Application number: 2023/93076	
What is the application for?:	External alterations to former bank building to form restaurant and takeaway, in
Address of the site or building:	former Lloyds Bank, 22, Carr Lane, Slaithwaite, Huddersfield, HD7 5AN
Postcode:	HD7 5UT

Type of comment: An objection	
Do you wish your comments to be published on the website anonymously?	Yes

Drawing Proposed Elevations	Scale @ A1 1:50
---------------------------------------	---------------------------

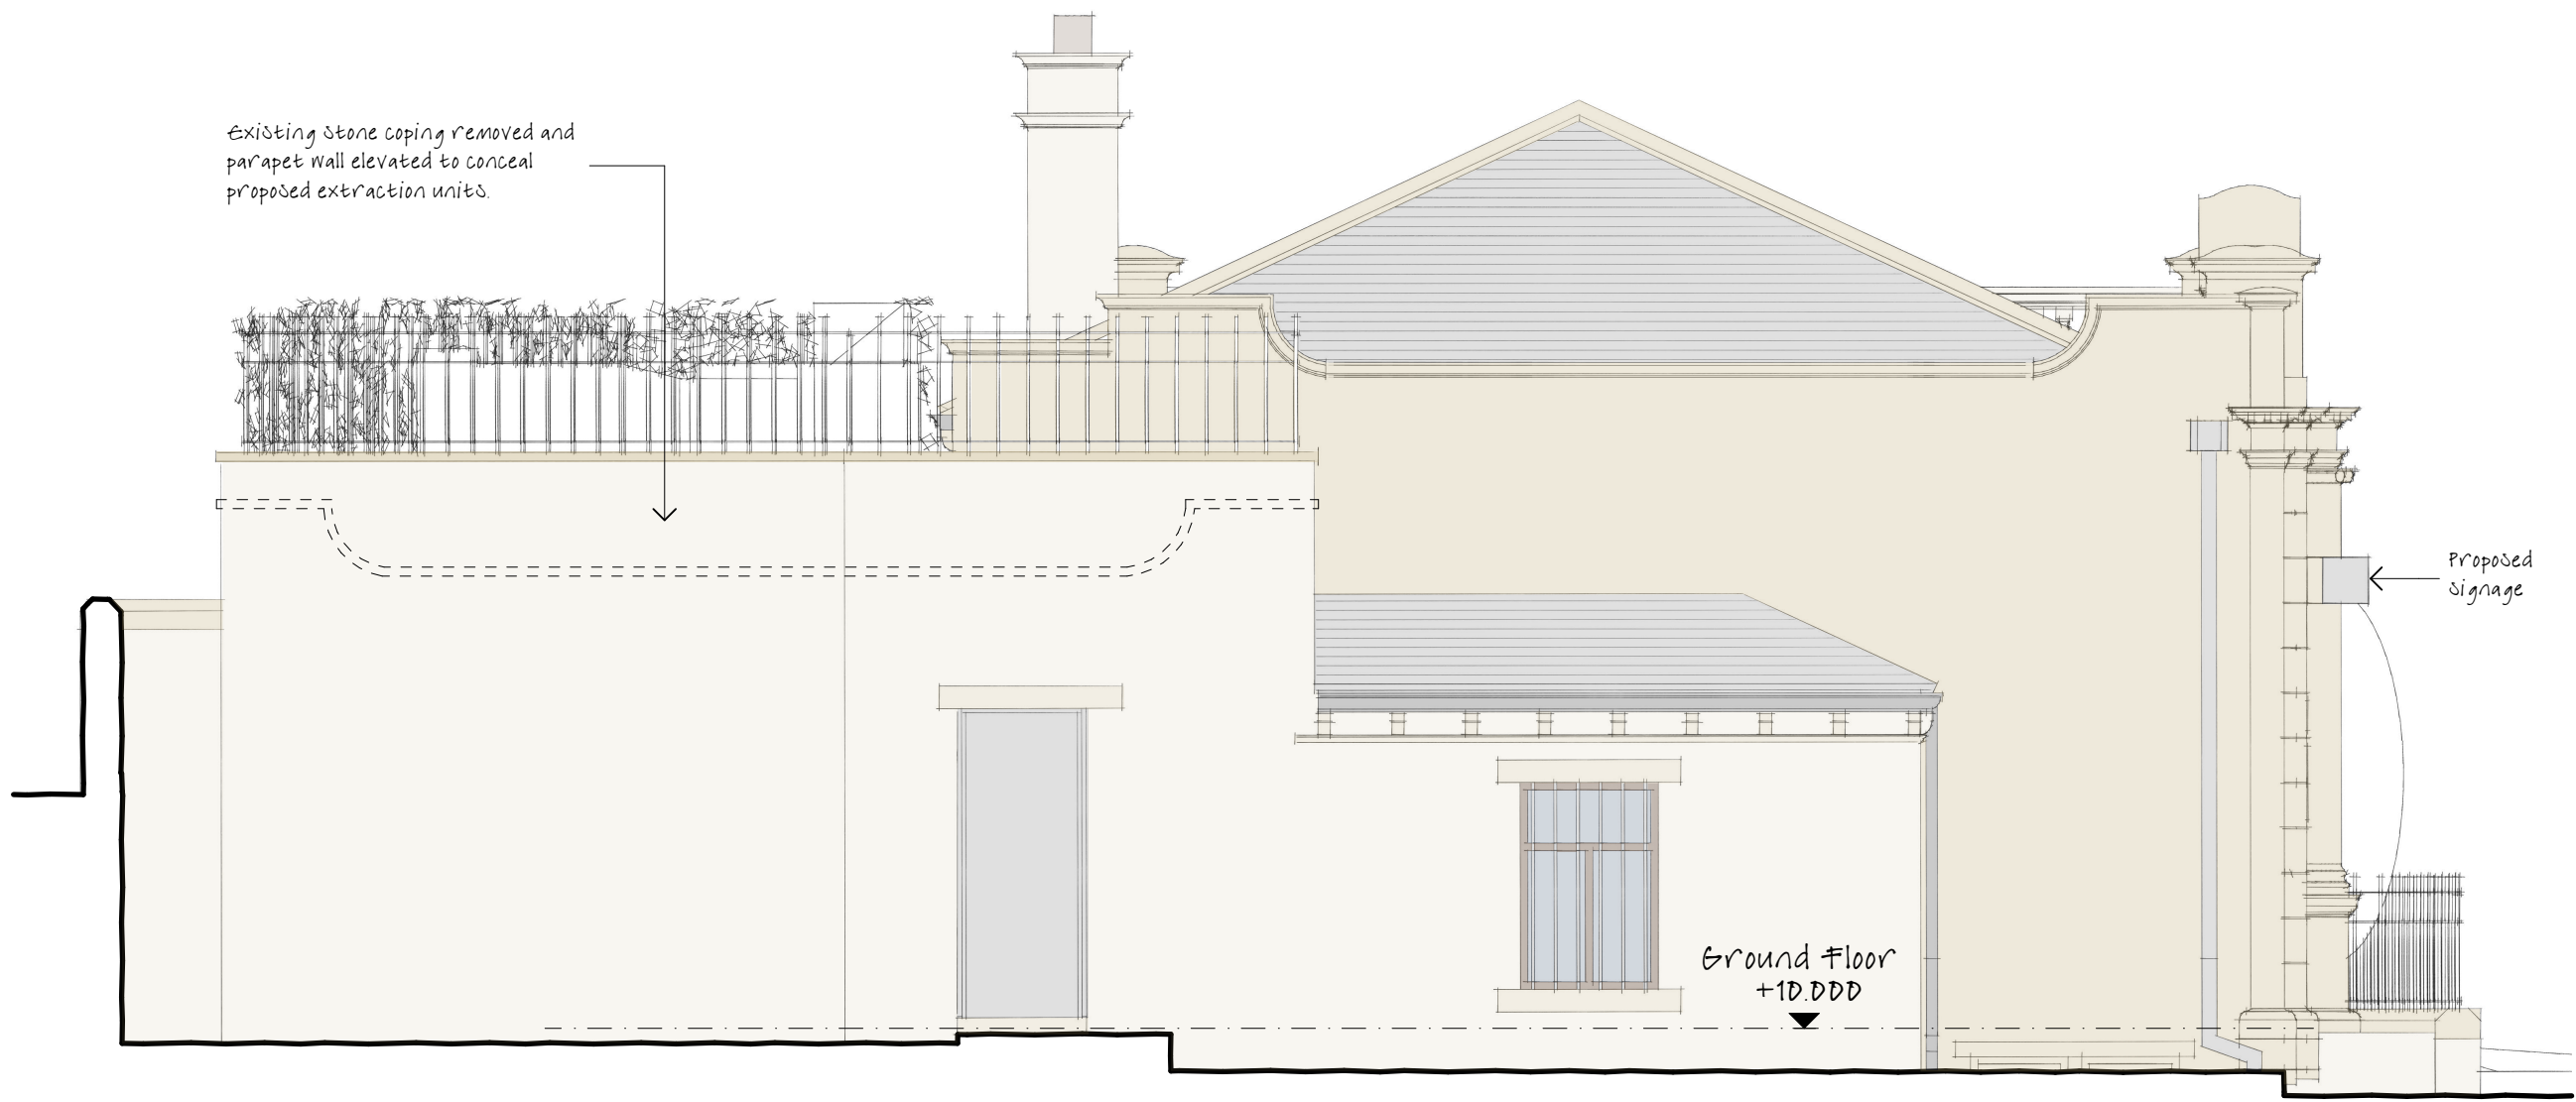
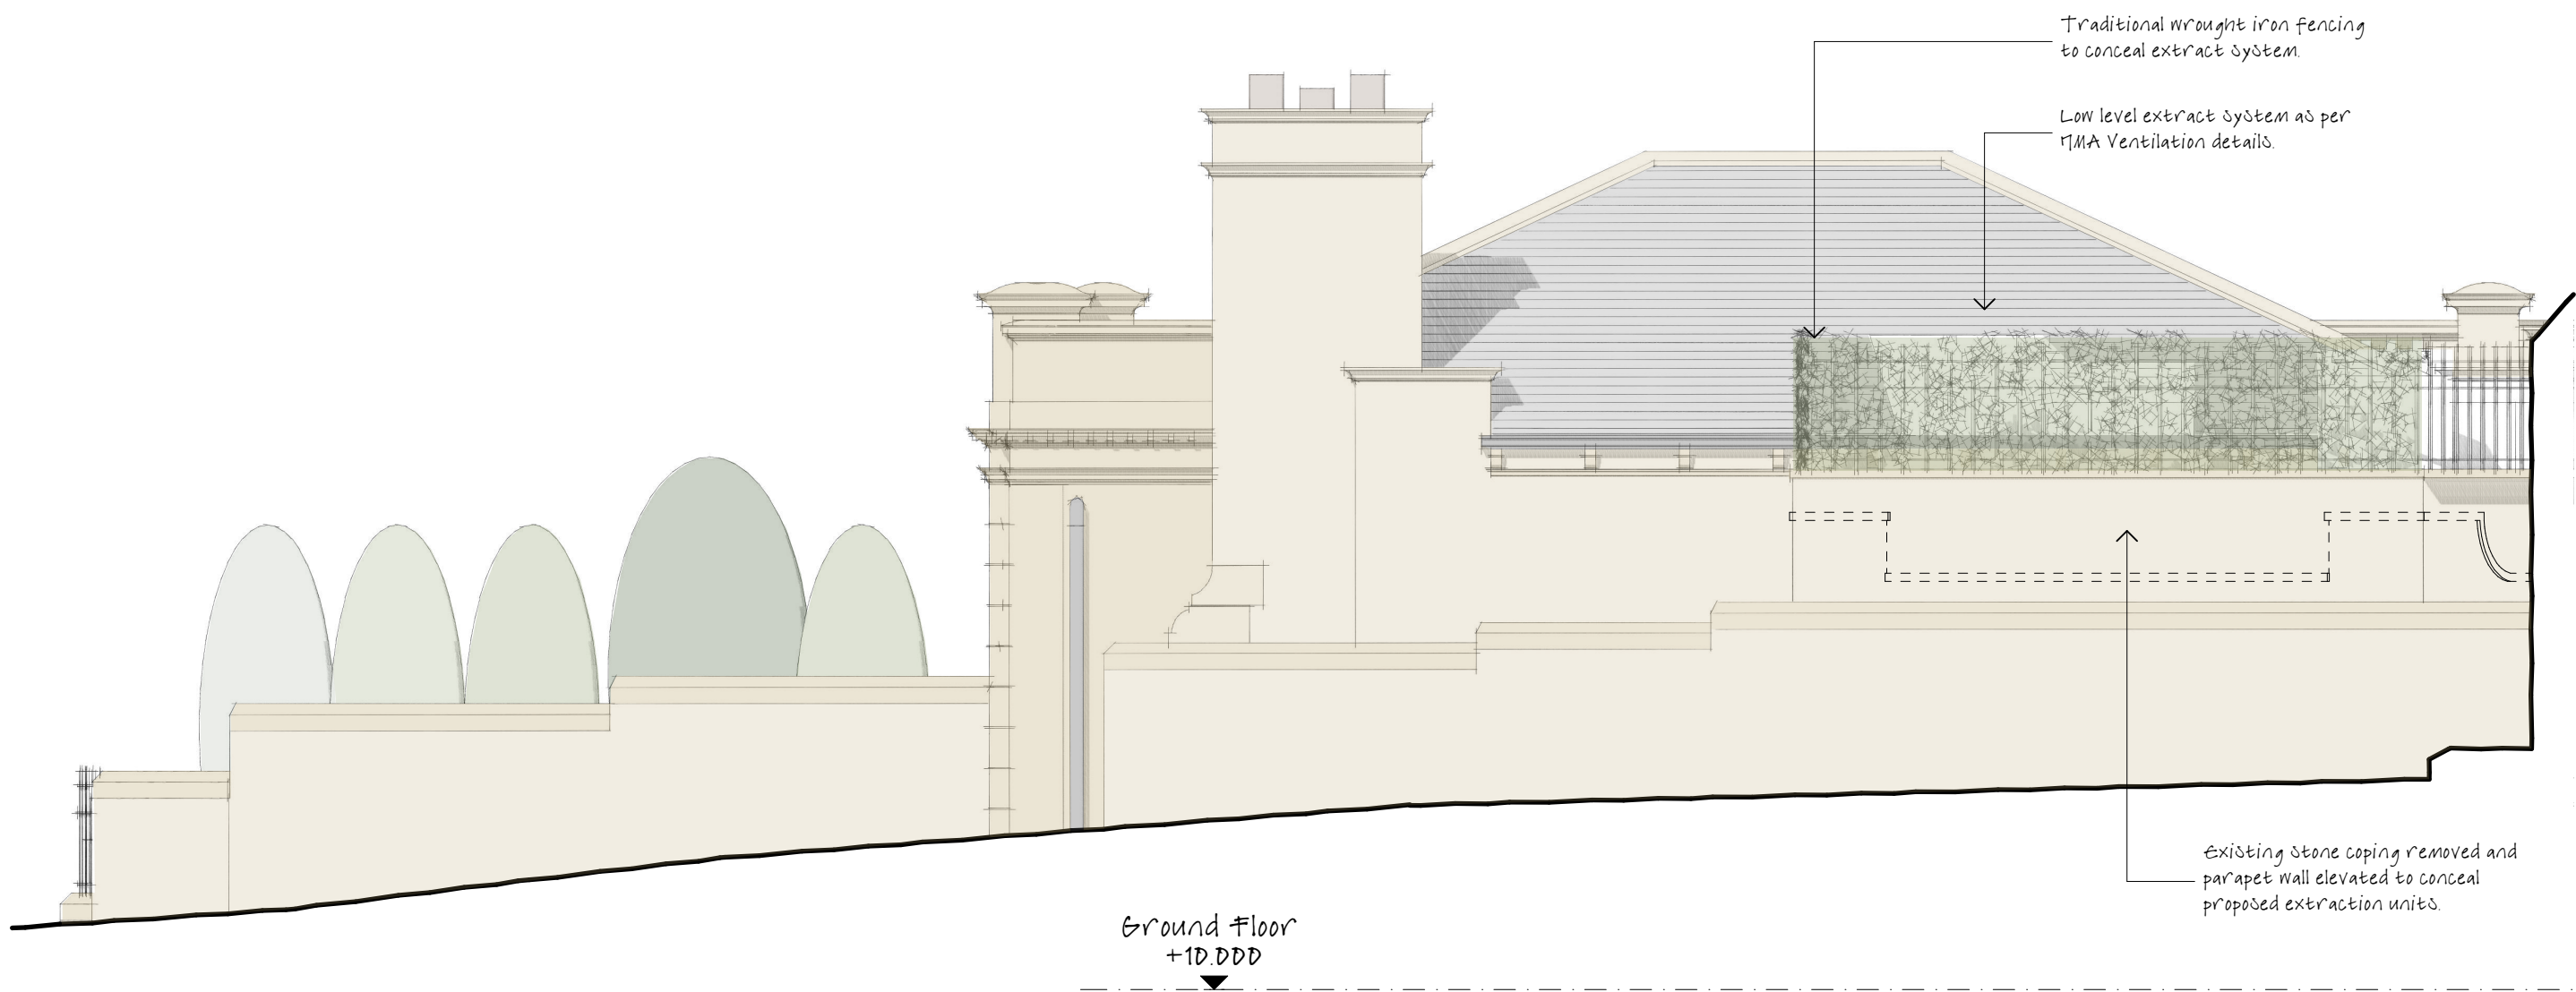
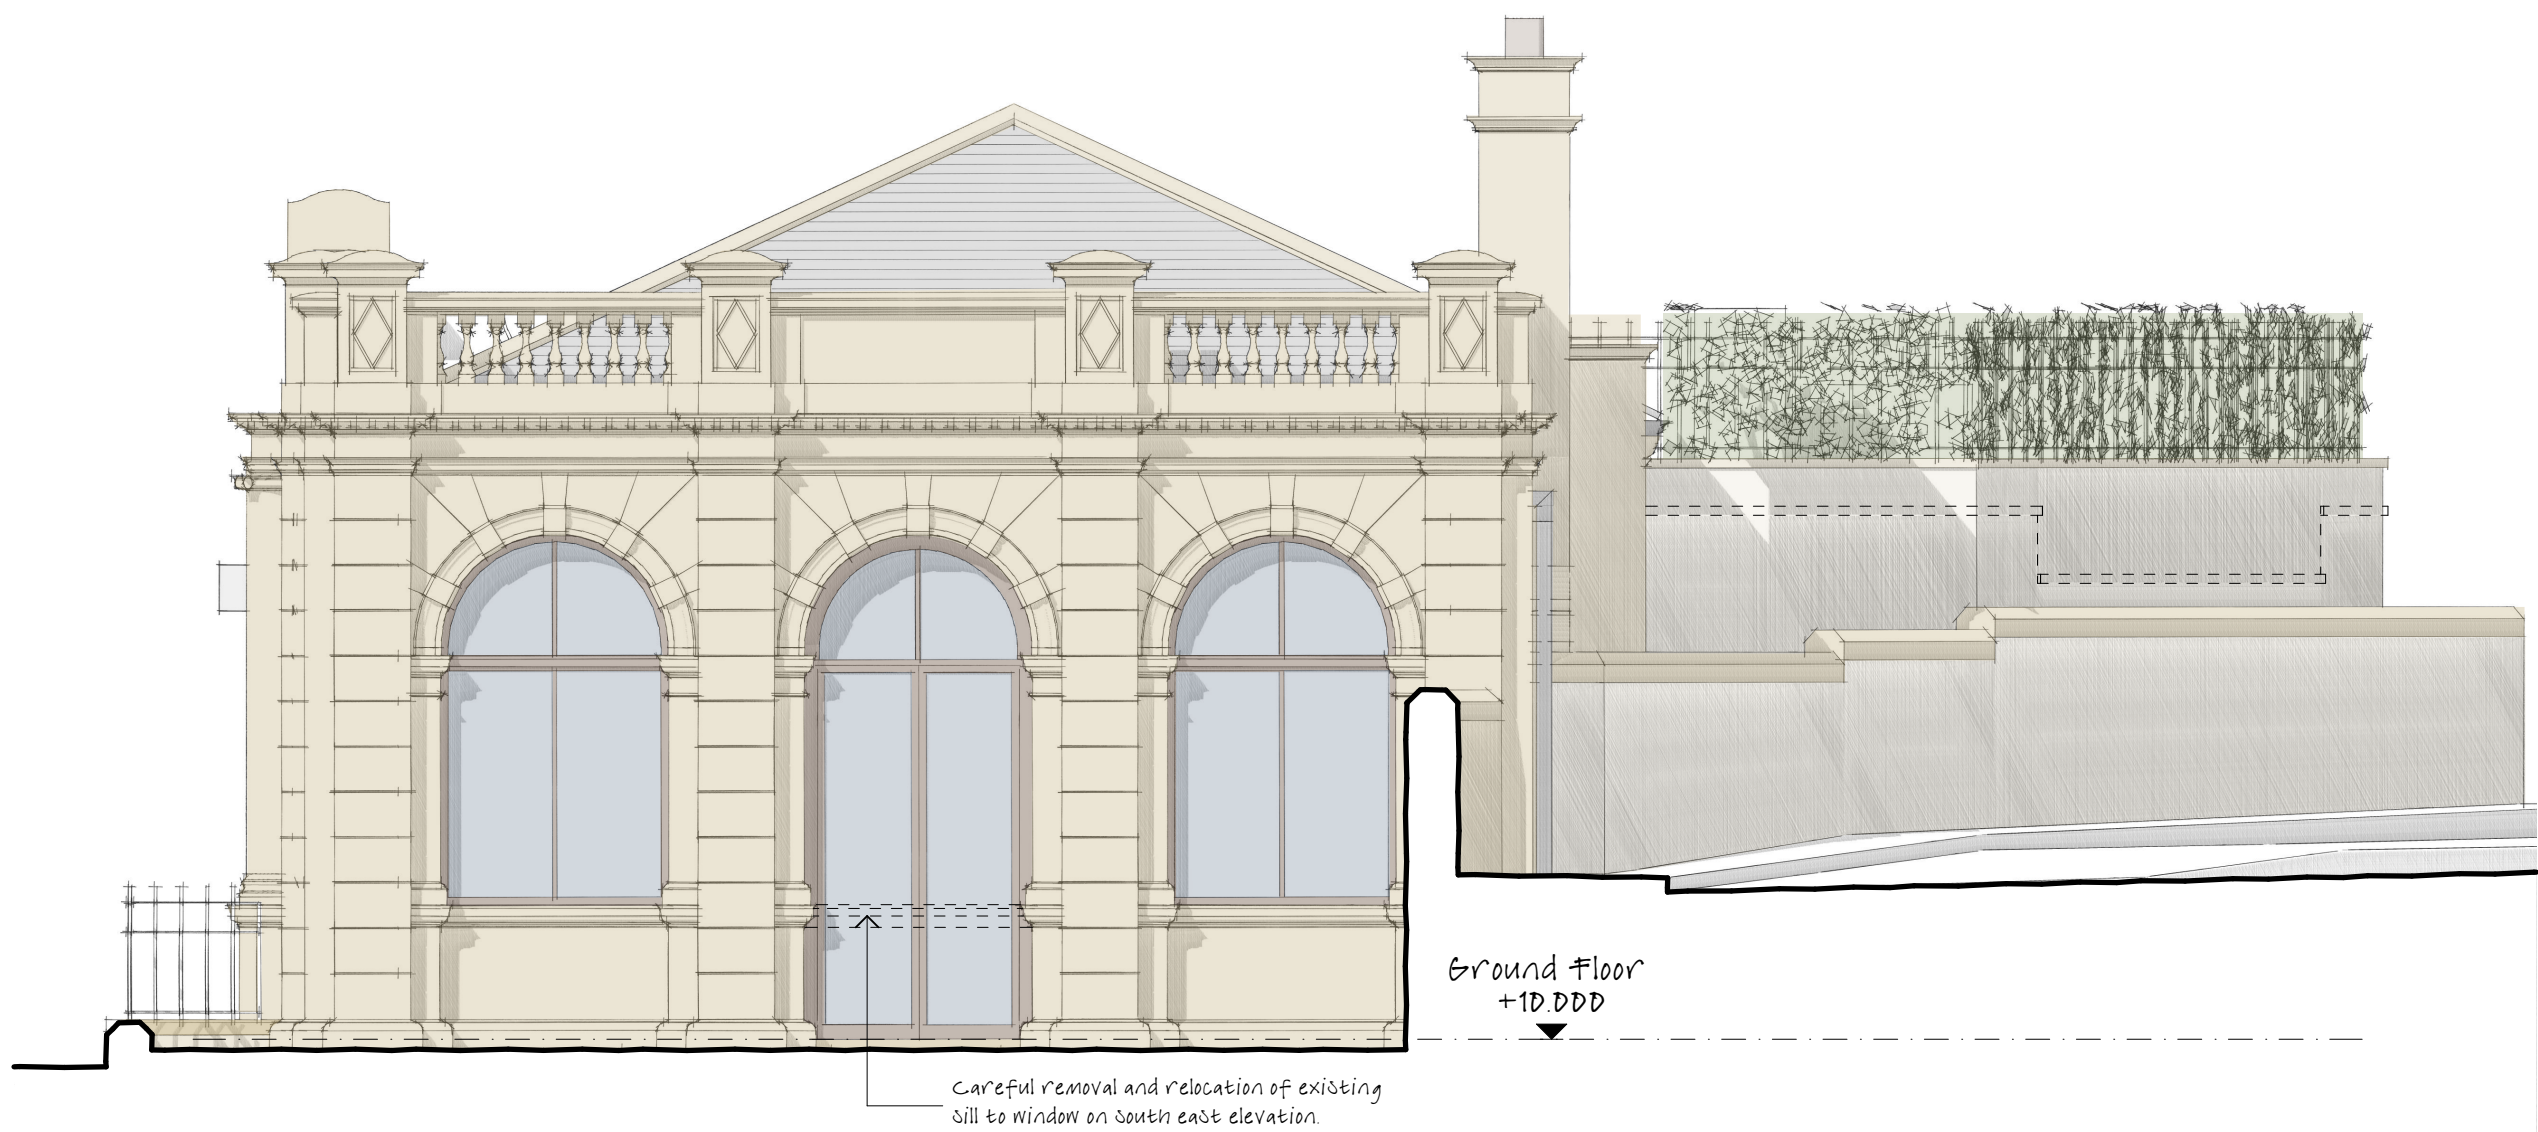
Excessive noise and smells and smoke from extractor fans that will not be limited to opening hours only and that will permeate directly into our property and prevent us opening windows due to the smell as the kitchen is to be situated backing on to Lewisham Road. The extraction fan will be directly level with the ground floor of our property, less than 10m from our boundary and the extraction system will be visible from the upstairs of our property. Having observed the amount of smoke and odour generated by the existing Rumpus in the village and the proposed siting of the extraction fan, Lewisham Road will be permanently in a fog of smoke.

Proposed outside seating area and the raising of an external wall and black railing will have an adverse effect on the character of the building and significantly effect the character of the area that backs on to Lewisham Road, along with the proposed extension that will alter the neoclassical style of the building, in what is a conservation area in Slaithwaite.
